EL PASO

PLANNING AND COMMUNITY DEVELOPMENT

Subject: VR-18-017 Cochise Road Vacation and Replat 1<sup>st</sup> review

BAR J-B ACRES FILING 2A

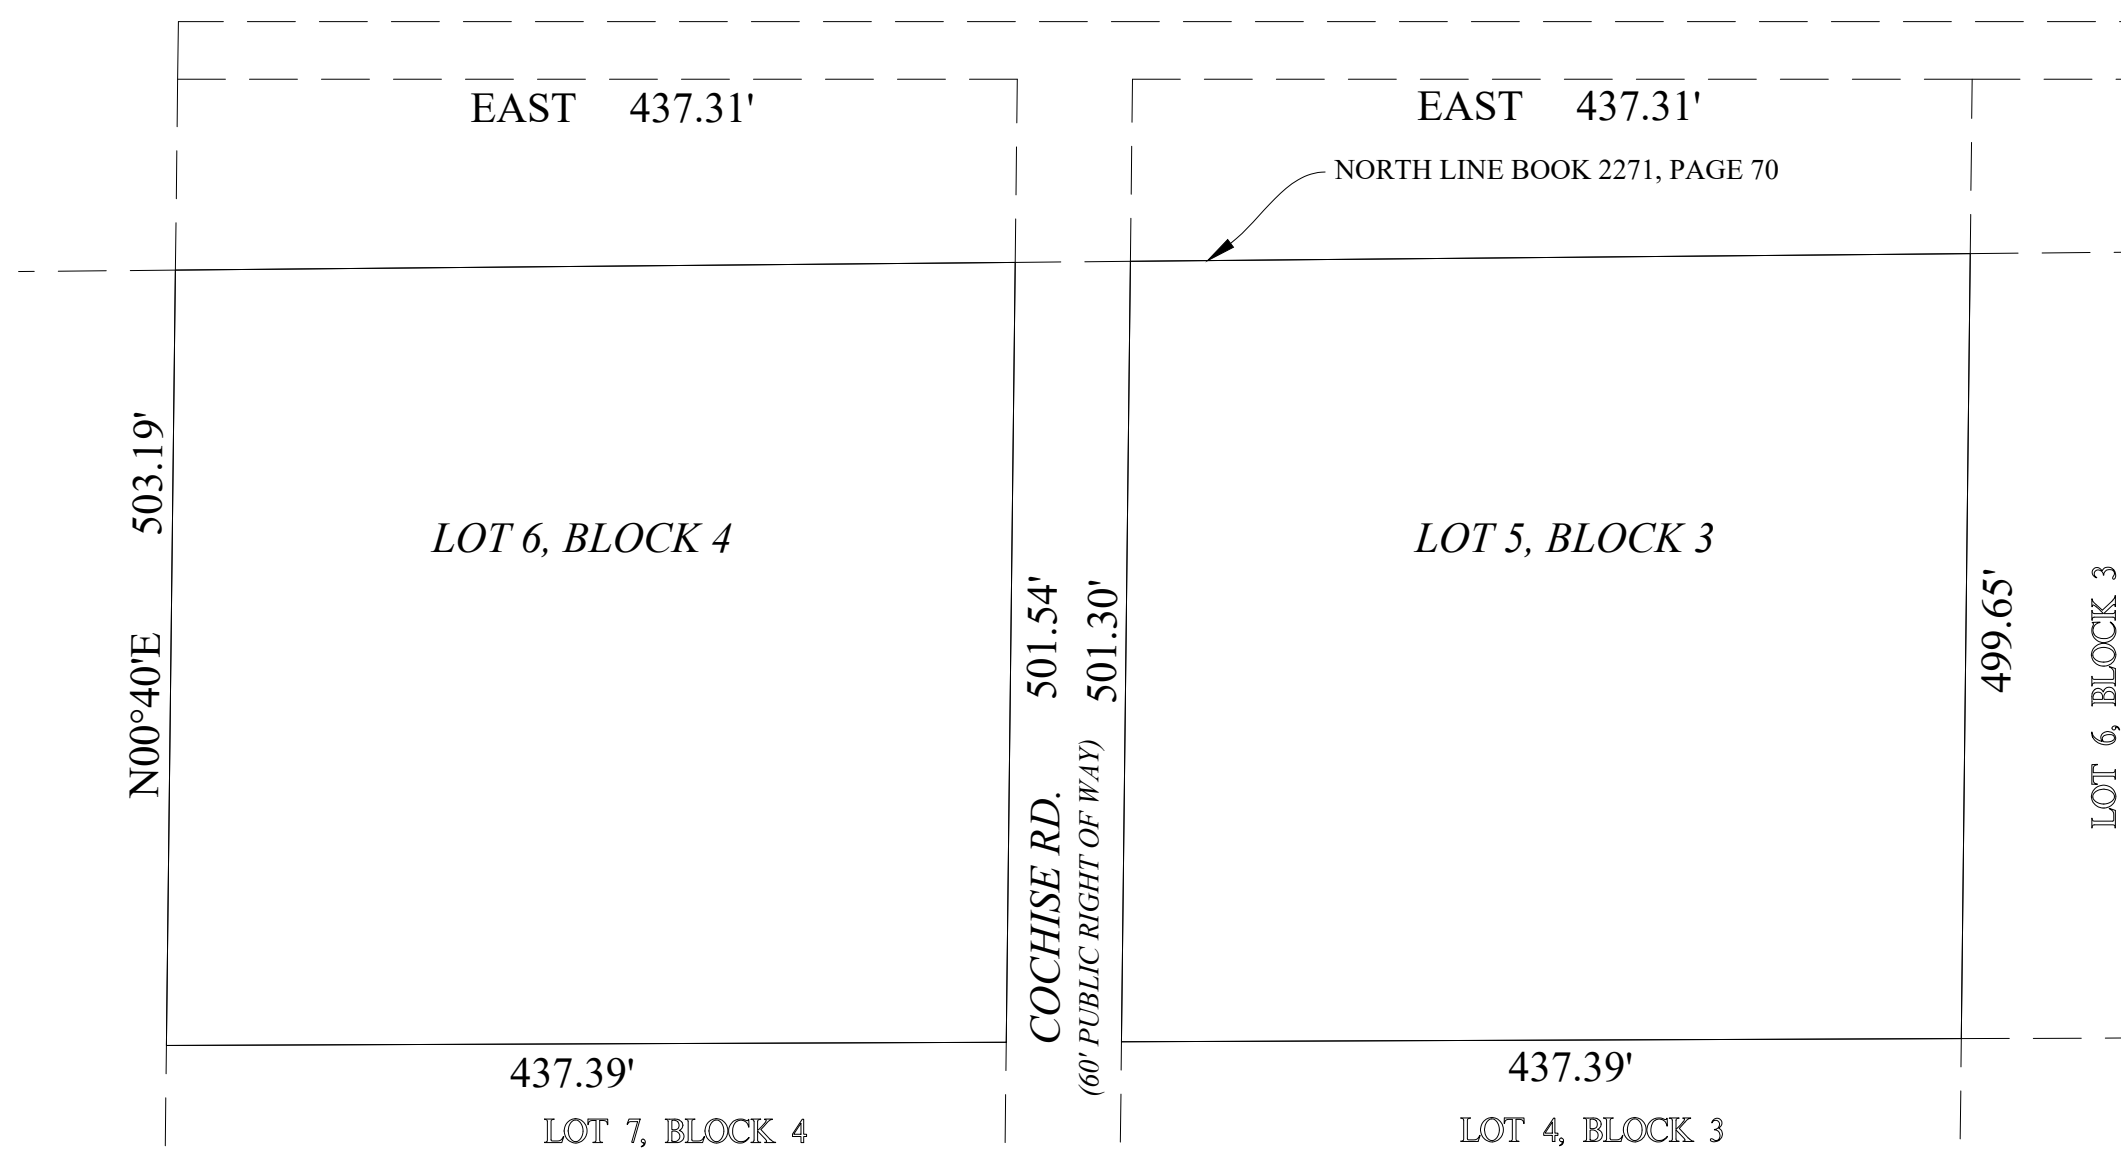
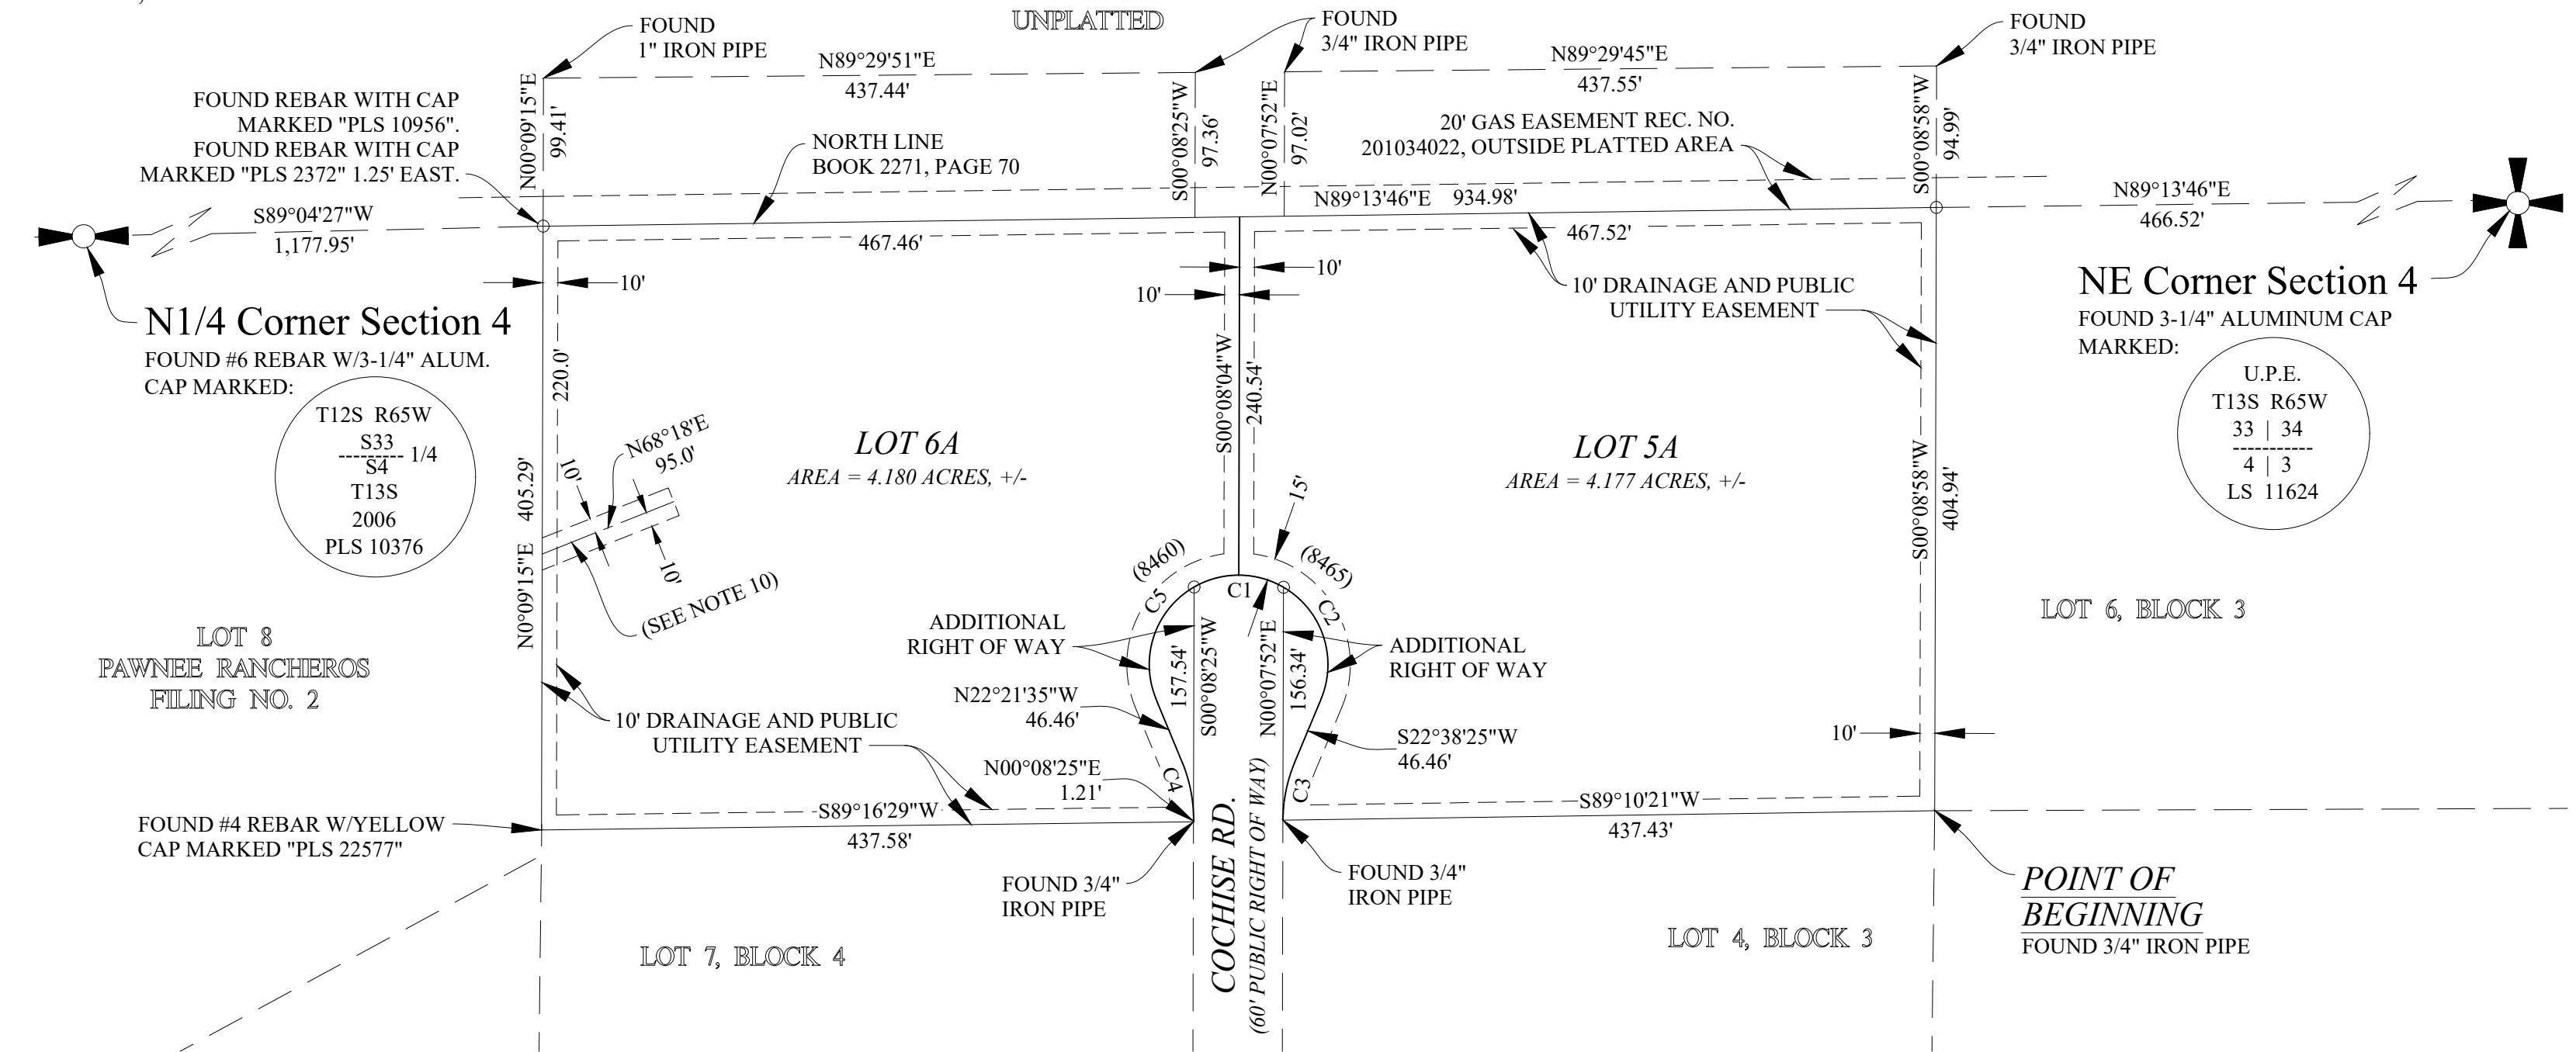
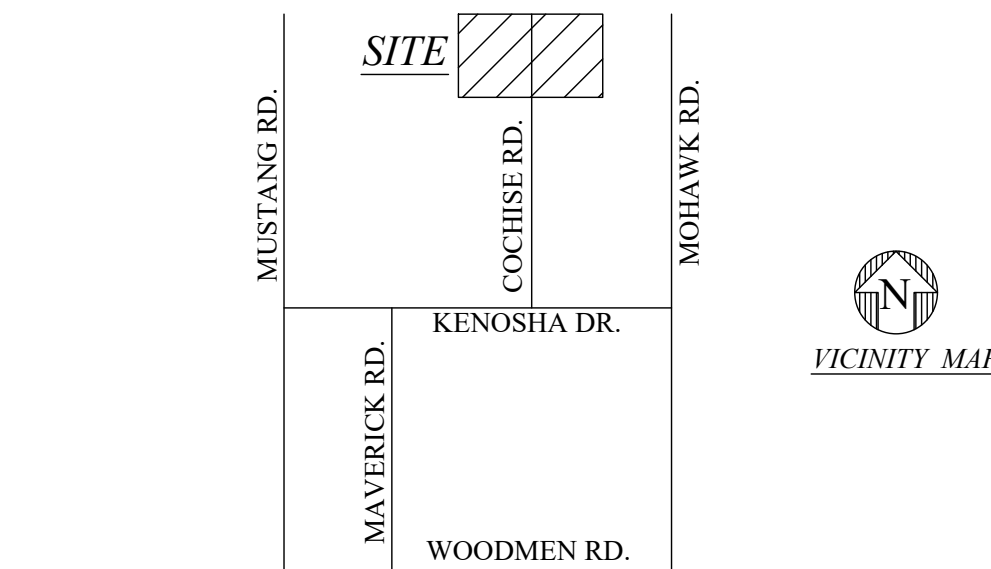
1. Show and label the existing CSU gas easement traversing both lots with reception number (201034022) and width. Also, this easement is undersized for the existing infrastructure and will need to be upsized to a 50ft utility easement to accommodate the high pressure gas.

- The 20 foot wide gas easement is now shown on the Plat. The easement is not on either property involved in this Replat therefore the easement is not being upsized to 50 feet wide.

Regarding a request for approval of Bar J-B Acres Third Filing, Enumerations has the following comments: 1. The addresses for the 2 lots involved will not change with this replat. The current addresses should be shown on the plat in the appropriate locations. 2. Prior to recording, Enumerations will review the mylar as per usual. Floodplain has no comment or objection. Brent Johnson Enumerations Plans Examiner Pikes Peak Regional Building Department O: 719-327-2888 E: [brent@pprbd.org](mailto:brent@pprbd.org) W: pprbd.org

- The address for each lot will remain the same and will be shown on the Plat.
- Enumerations will review the Plat prior to recording.
